WAYNFLETE LOWER SCHOOL - ADDENDUM #4 [post bid]

date: Friday, March 31, 2017
project: Waynflete Lower School Addition & Renovations, 2013-0050
prepared by: Austin Smith Scott Simons Architects
to: Cordelia Pitman Wright Ryan Construction
Rick Bergeron Wright Ryan Construction
Luke Dione Wright Ryan Construction
Anne Hagstrom Waynflete School
Patrick Boure Waynflete School
Phil LaClaire PML Project Management

Subject: Addendum #4 to Bid Documents of January 12, 2017

7 FOUNDERS 4-5 ELEVATION
SCALE: 1/4" = 1'-0"

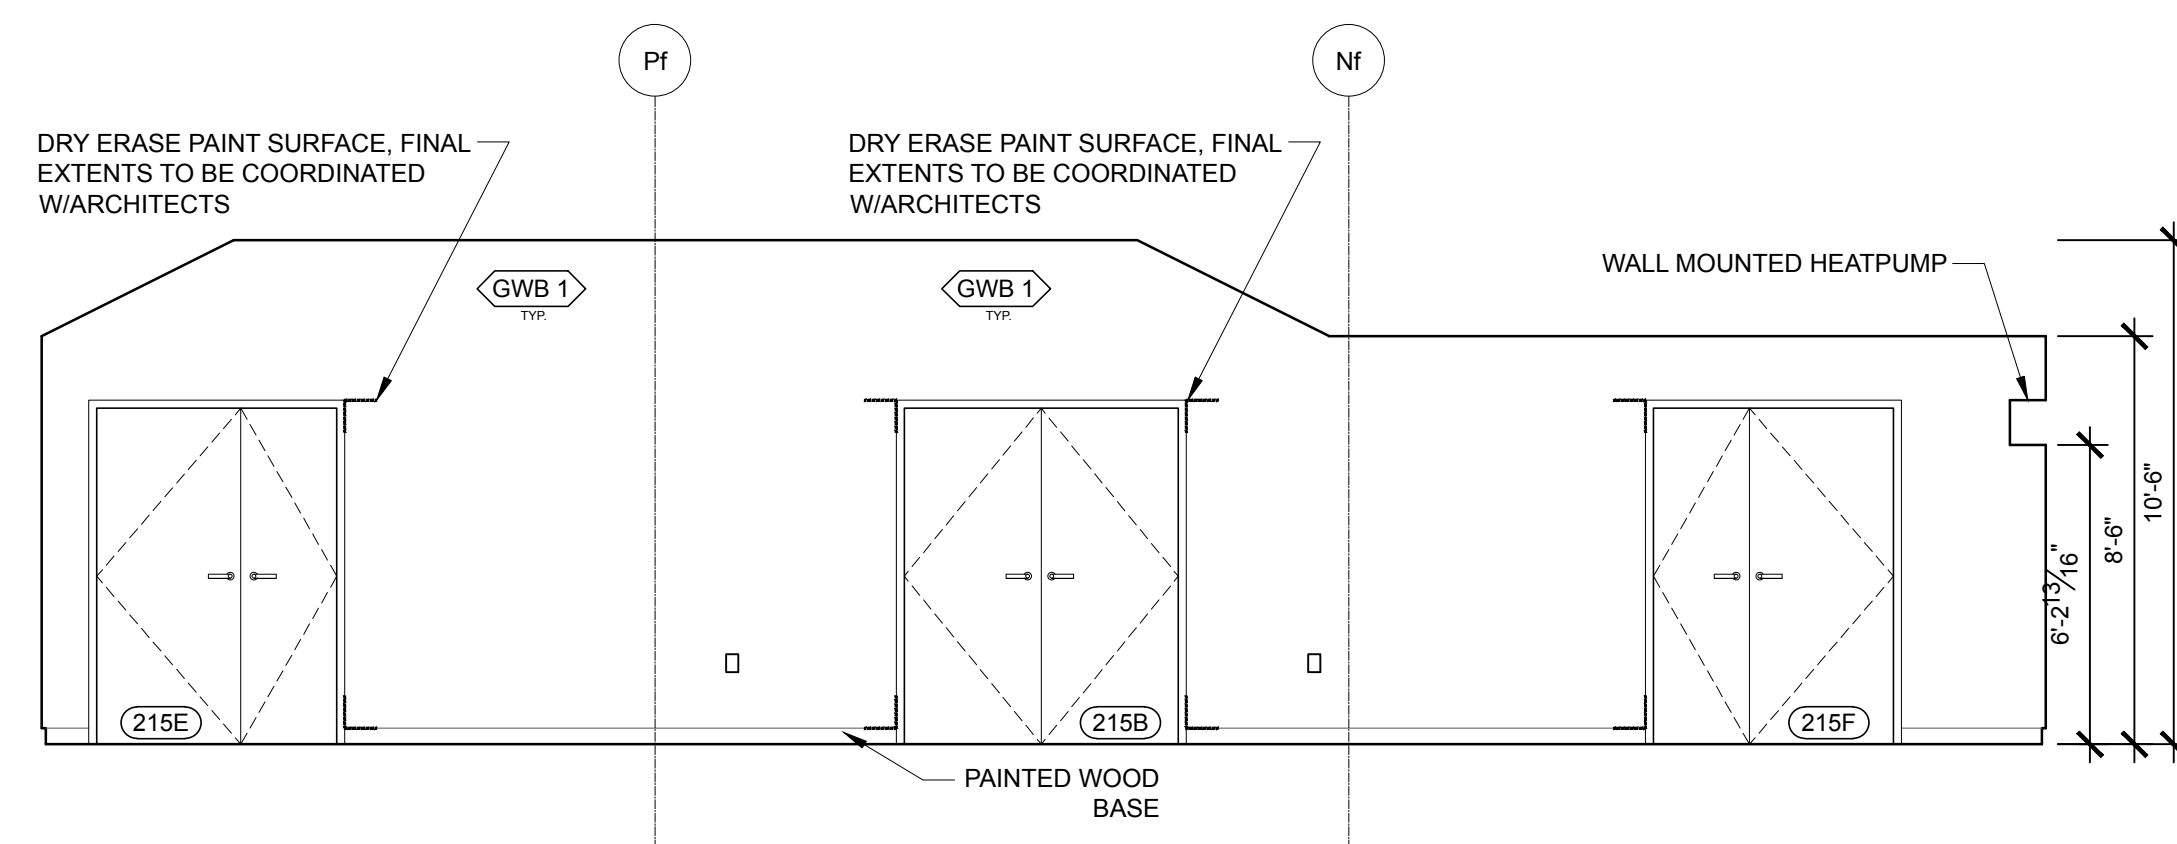
- 4-D1 Sheet A131 At "Exterior GWB Soffit" Note:
Add: ": Provide level 5 finish skim-coat over sheathing, typical. Provide V-groove vinyl trim at control joints"
- 4-D2 Sheets A523,
A525
A536
A528 At classroom interior elevations all instances of this note:
Delete: "Dry erase paint surface, final extents to be coordinated w/ architects"
- 4-D3 Sheet A601 Under General Notes related to the Door and Frame Schedule:
Add: "5. All paired doors with combination 3'/2' doors, the 2' leaf shall be inactive with use of egress hardware"

SKA-09
22 Feb 2017
MOTORIZED SHADE
CLARIFICATION
p 2 of 2

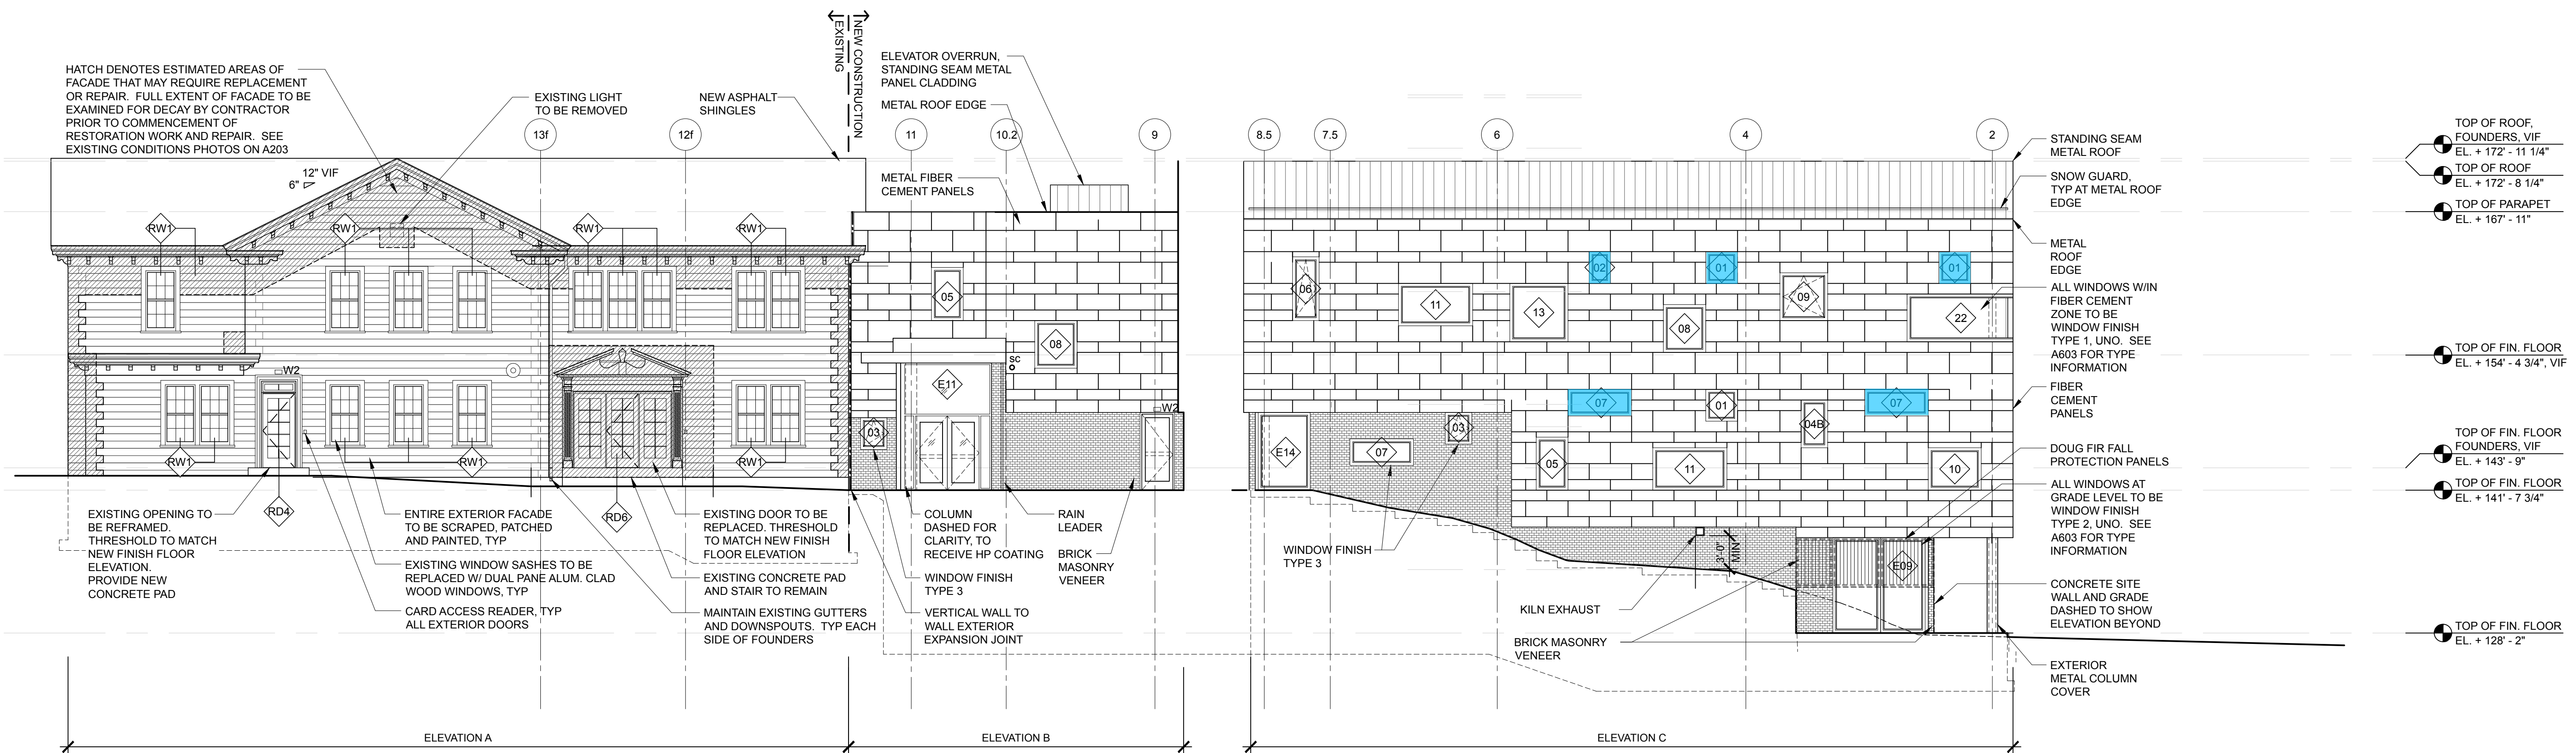
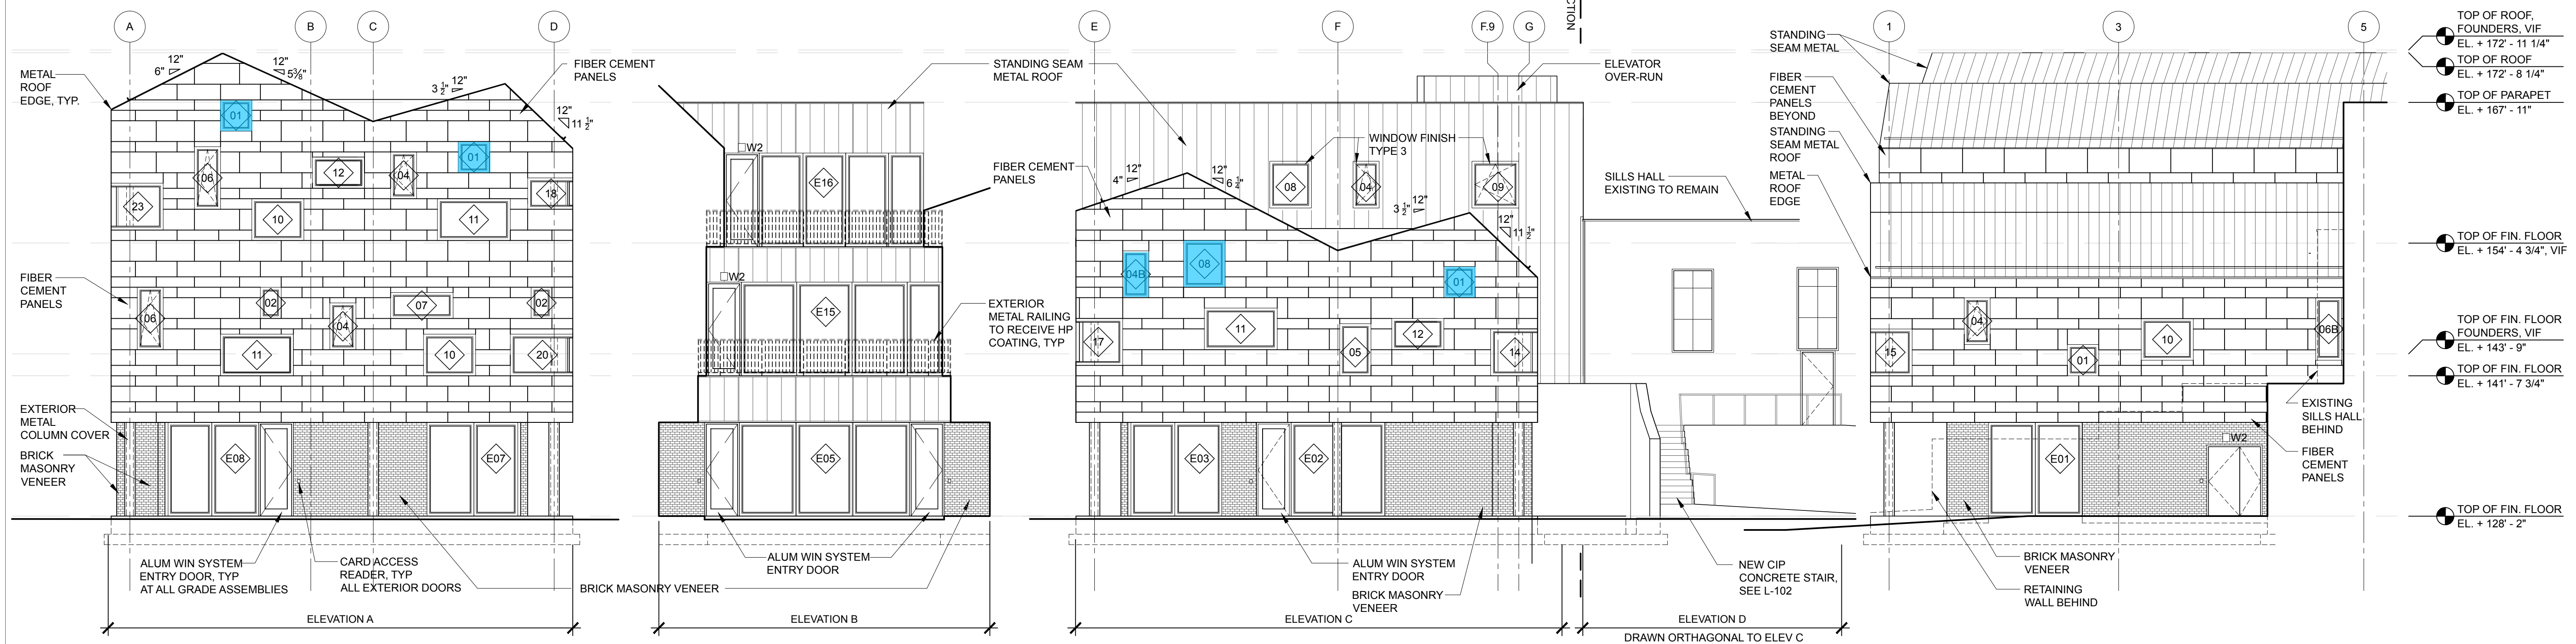
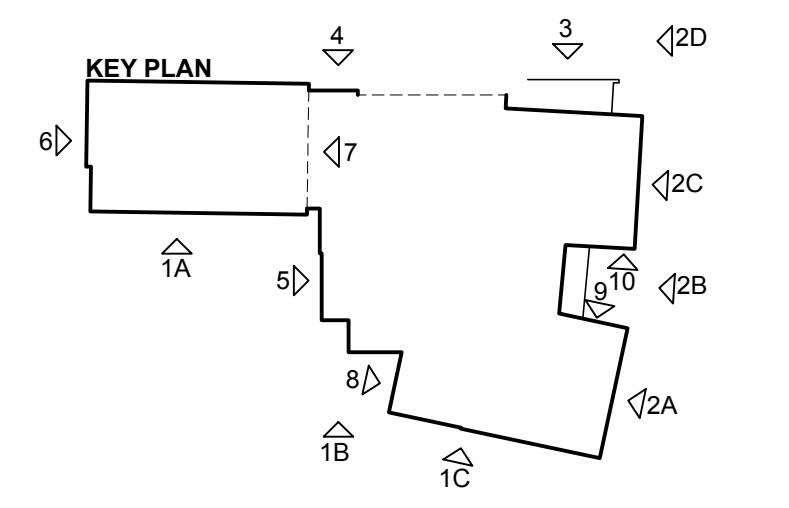
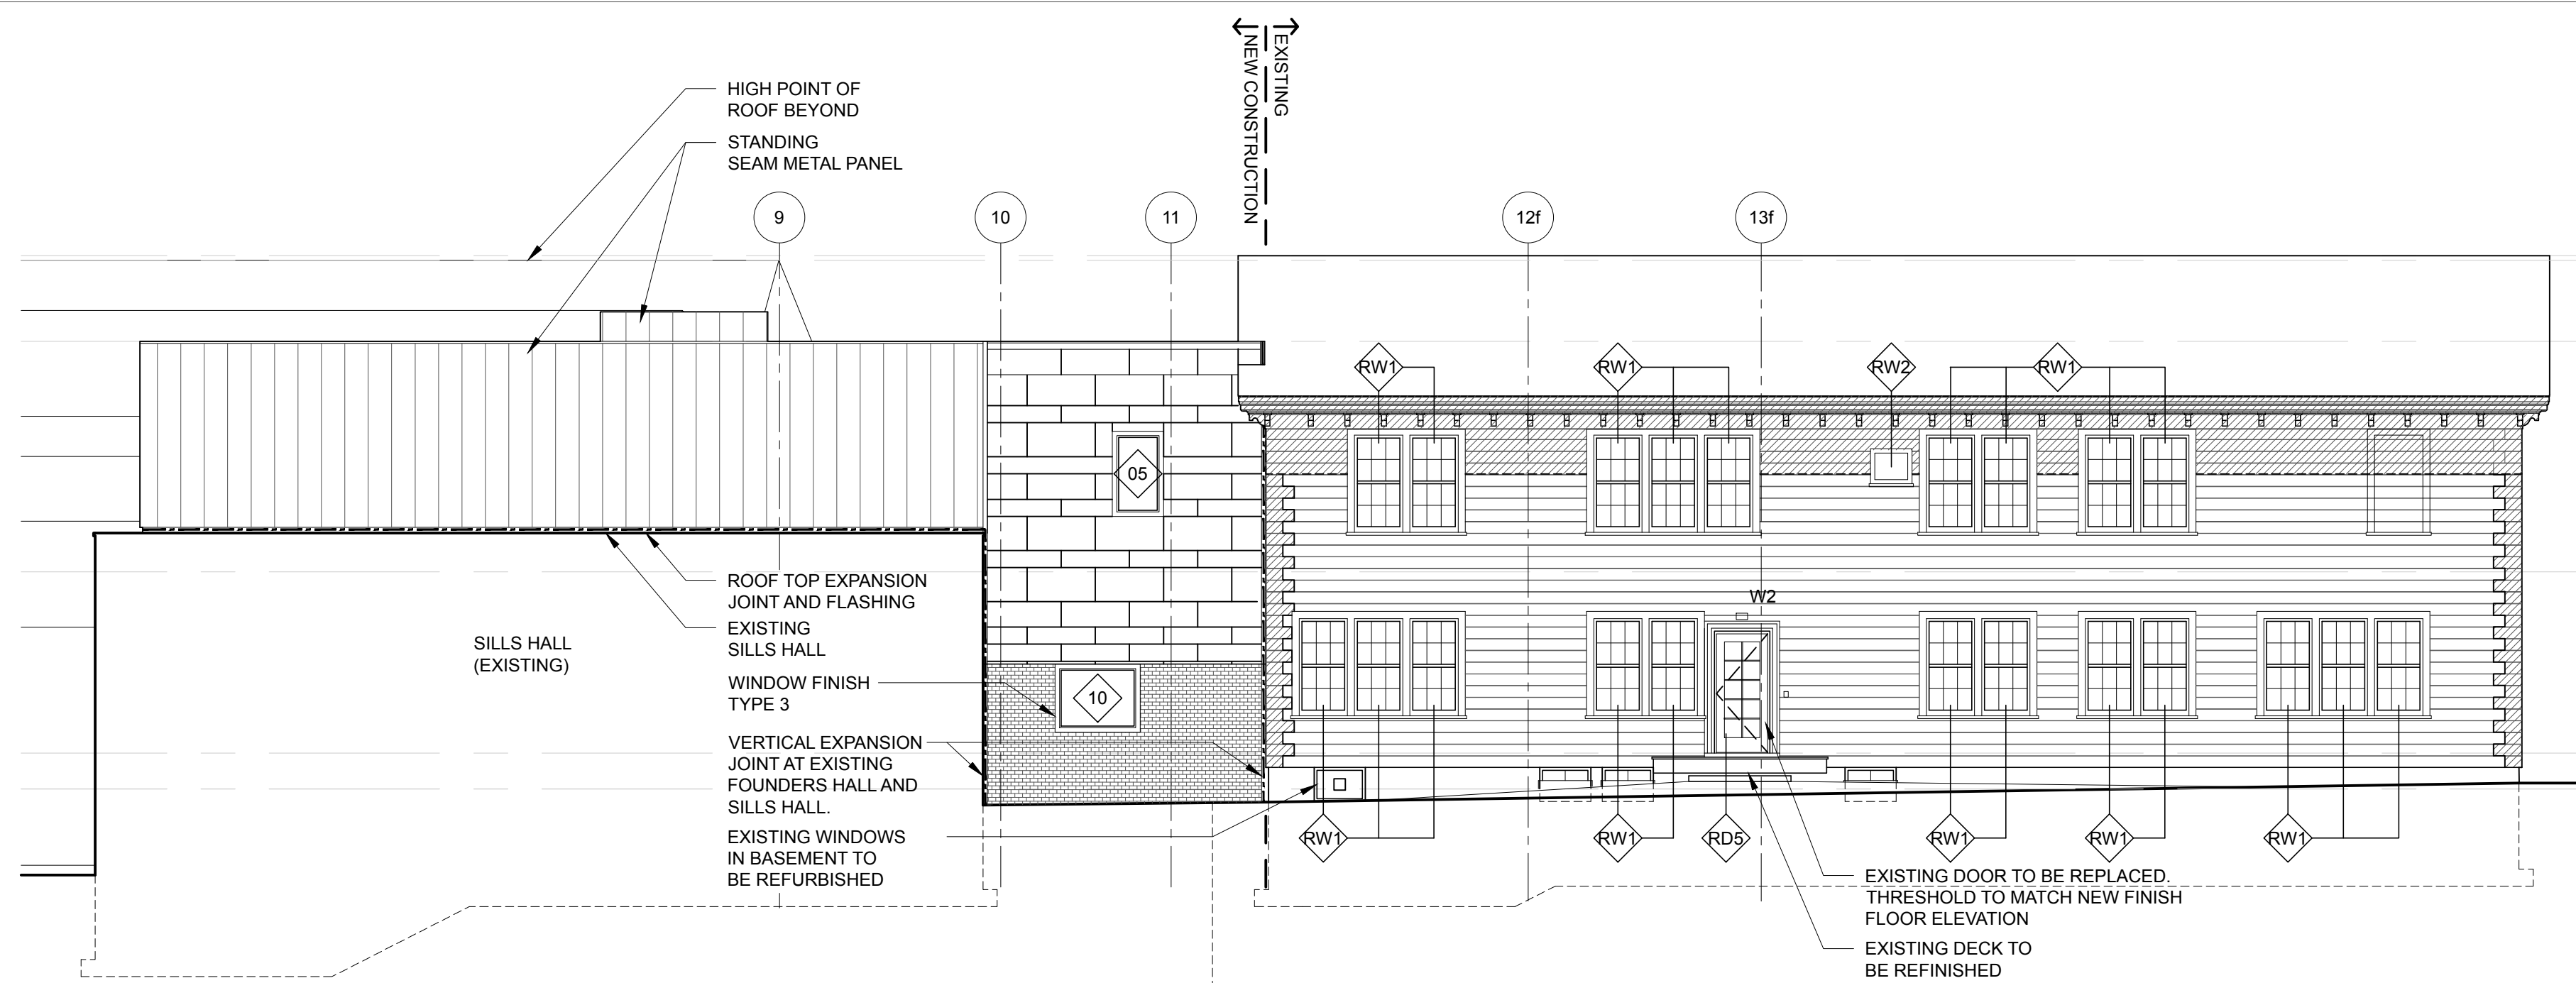
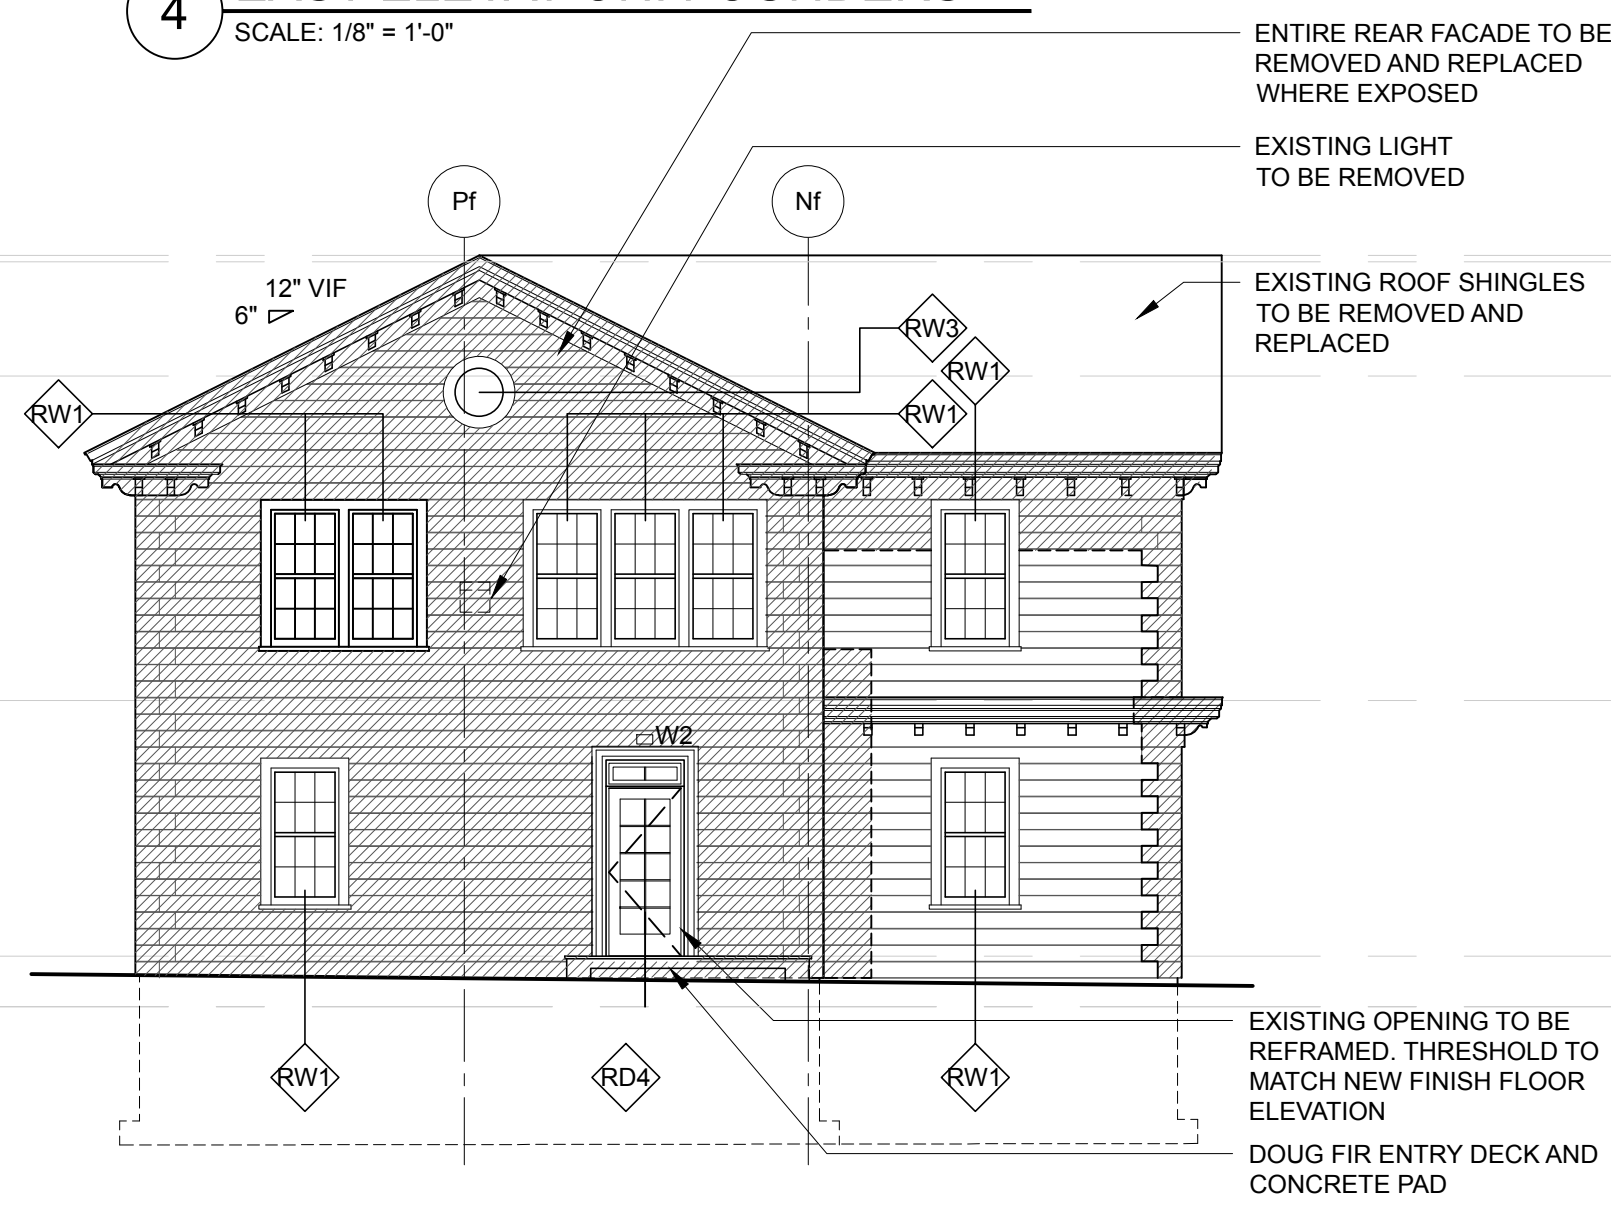
- 4-Q12 Question 12 Q: Please clarify extent of battery powered shades.
A: Please see SKA-09, Motorized Shade Clarification.
- 4-Q13 Question 13 Q: Please clarify requirement for wood strapping at fiber cement panels.
A: Per James Hardie Product Data, "the fastener chosen must be fully encompassed by a wood substrate - the furring may count as all or part of the necessary penetration if it has been proven that the furring and/or wood substrate has the same or better holding power as a timber stud." See manufacturer's recommendation for fastener depth.
